CITY OF ALBUQUERQUE

**Re: Lot 6 Block 4 Unit 18 Volcano Cliffs, S.A.D. 228
6600 Papagayo NW
Request Permanent C.O. – Accepted
Engineer's Stamp dated: 1-2-18 (D10D003J6)
Certification dated: 2/11/19**

CITY OF ALBUQUERQUE, BERNALILLO COUNTY				NEW MEXICO	
LOT 6, BLOCK 4, UNIT 18 VOLCANO CLIFFS SUBDIVISION					
PECK (BUILDER: MICHAEL SANCHEZ) – GRADING & DRAINAGE PLAN					
McDowell Engineering, Inc.					
7820 BEVERLY HILLS AVE. NE • ALBUQUERQUE, NM 87122					
TELE: 505-828-2430 • FAX: 505-821-4857					
Designed	JSM	Drawn	STAFF	Checked	JSM
					Sheet of
File	PEC0117L		Date	DECEMBER, 2017	
				1	1

**Re: Lot 6 Block 4 Unit 18 Volcano Cliffs, S.A.D. 228
6600 Papagayo NW
Request for Permanent C.O. – Not Accepted
Engineer's Stamp dated: 1-2-18 (D10D003J6)
Certification dated: 1/23/19**

PECK (BUILDER: MICHAEL SANCHEZ) — GRADING & DRAINAGE PLAN

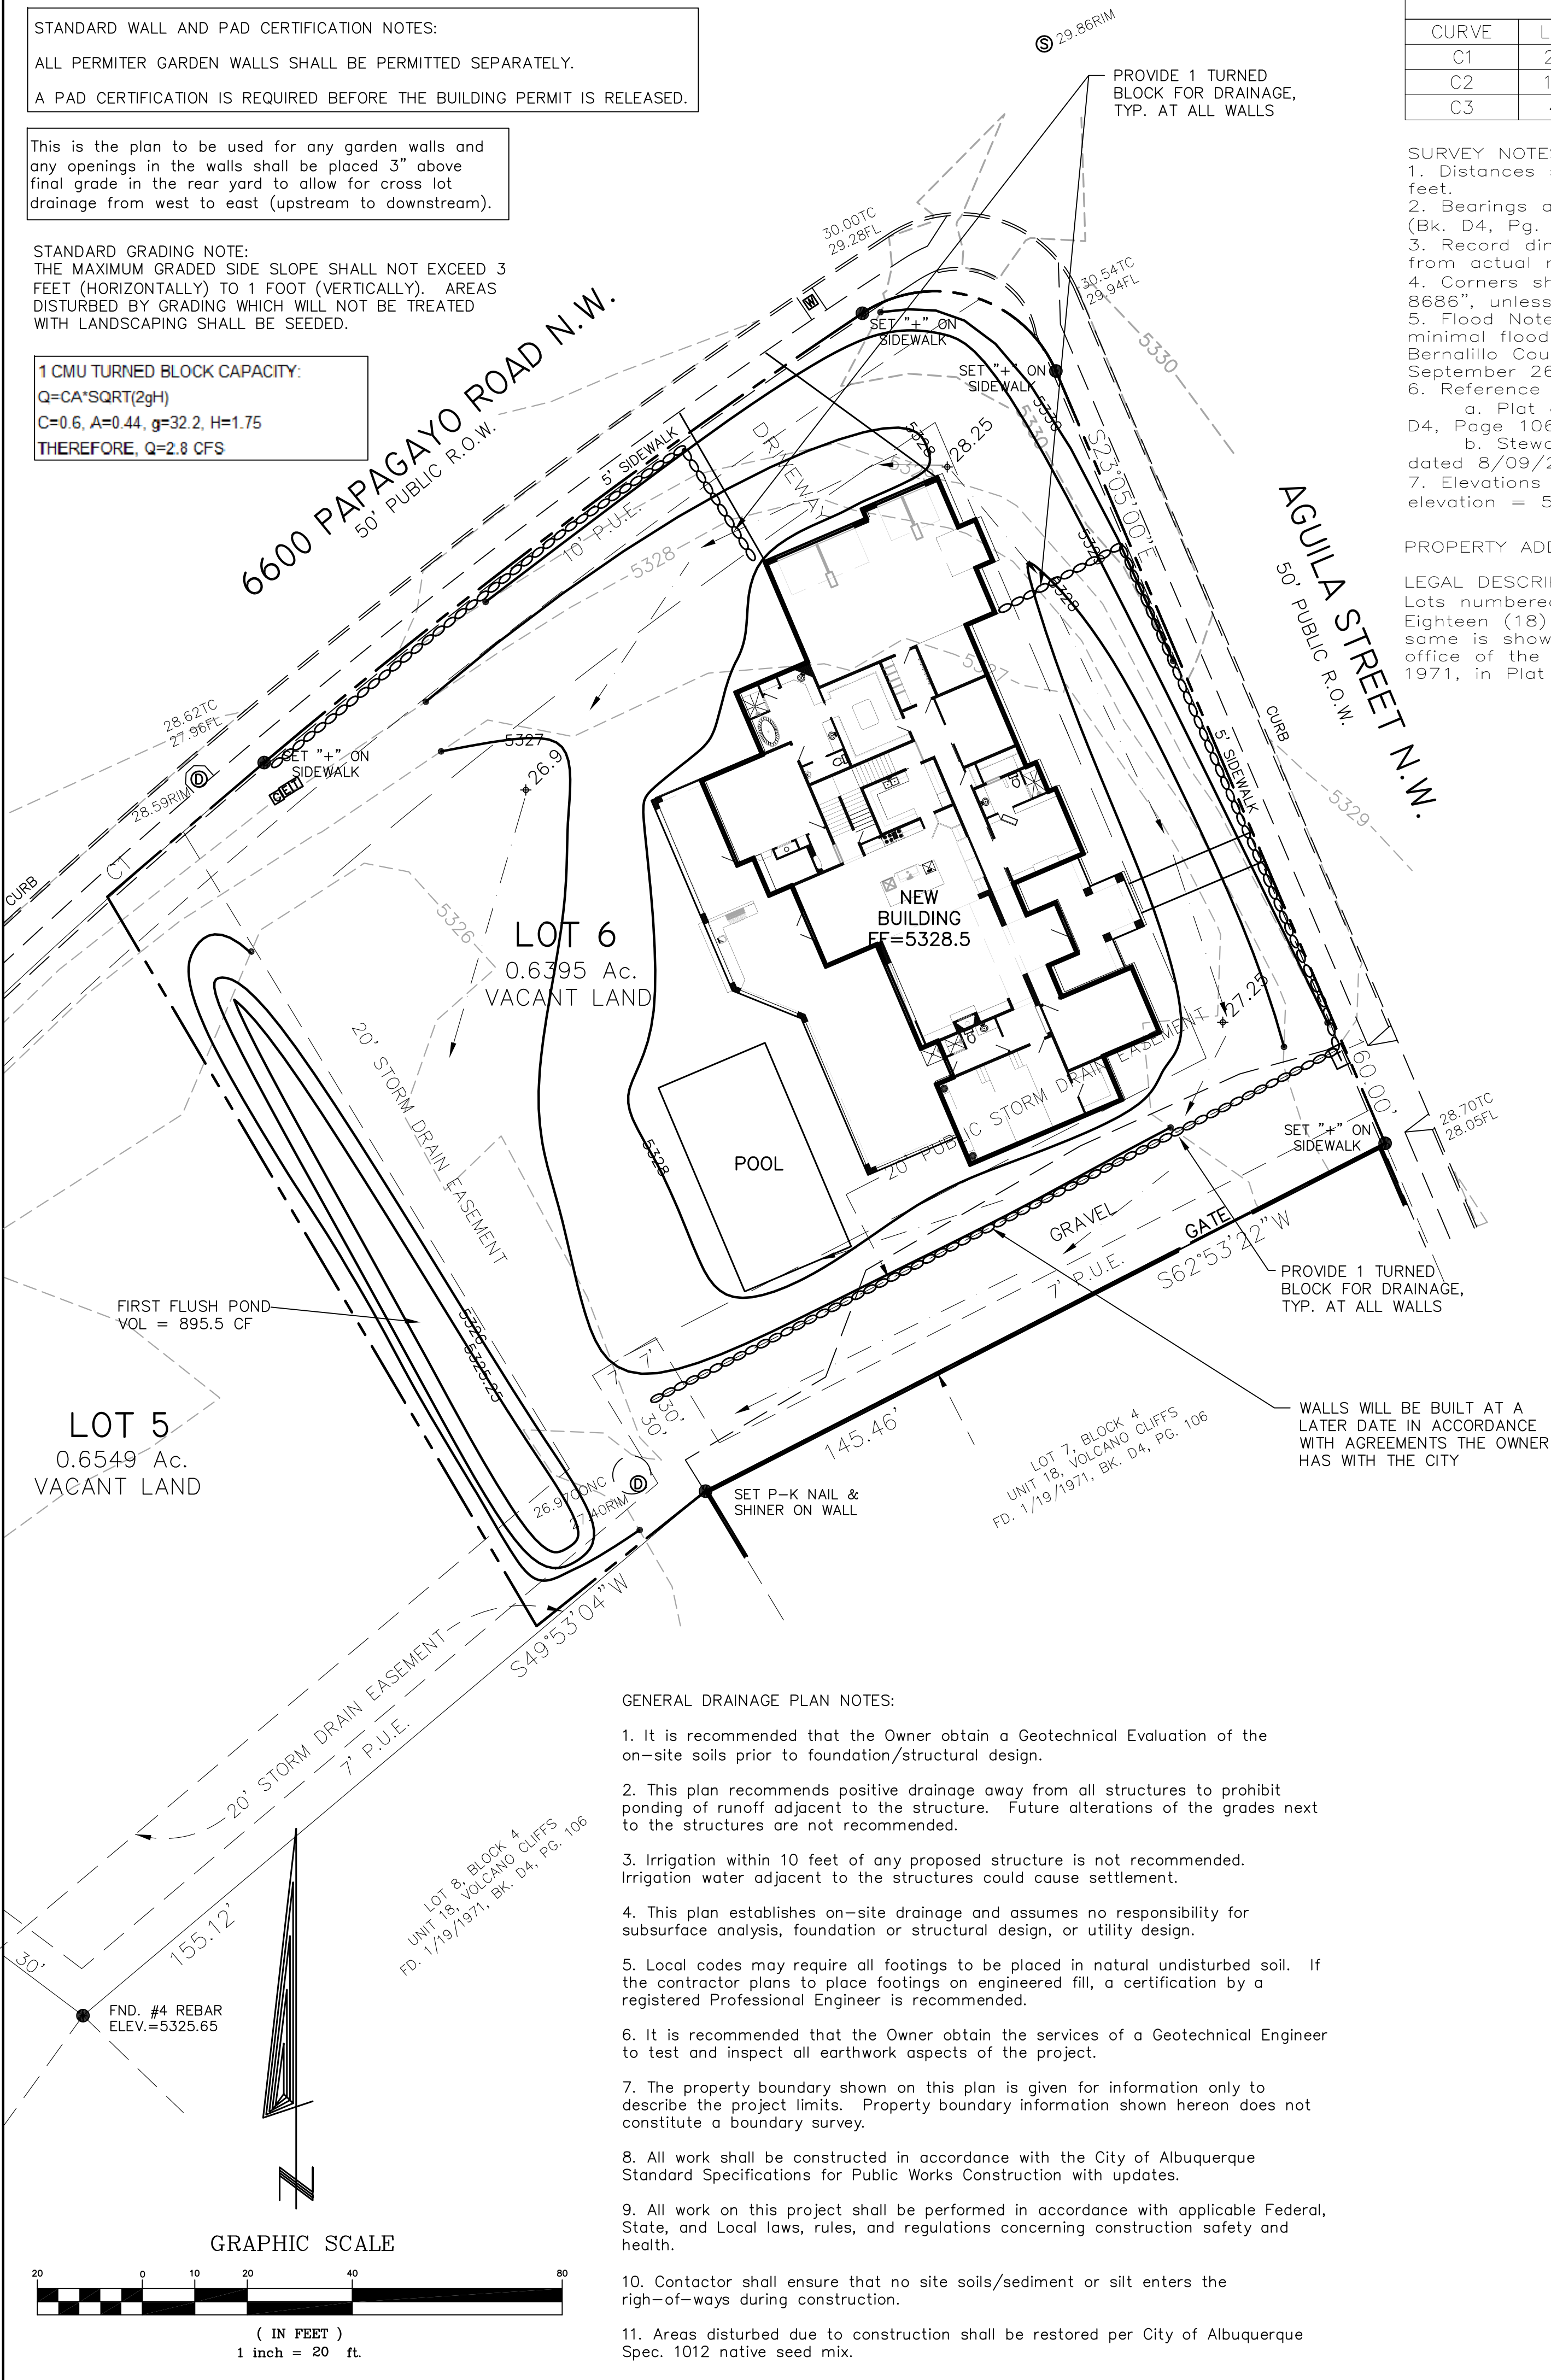
- Provide the new plat for this address, it appears that the lot line was moved. **attached**
- Provide the location of the 20' SD easement, one of the hatched lines are missing. **updated**
- Provide the new calculations including the pool area. Treatment D should have increase along with the ponding area. **updated, even though pools typically store water, updated to treat as Treatment D, per your direction.**
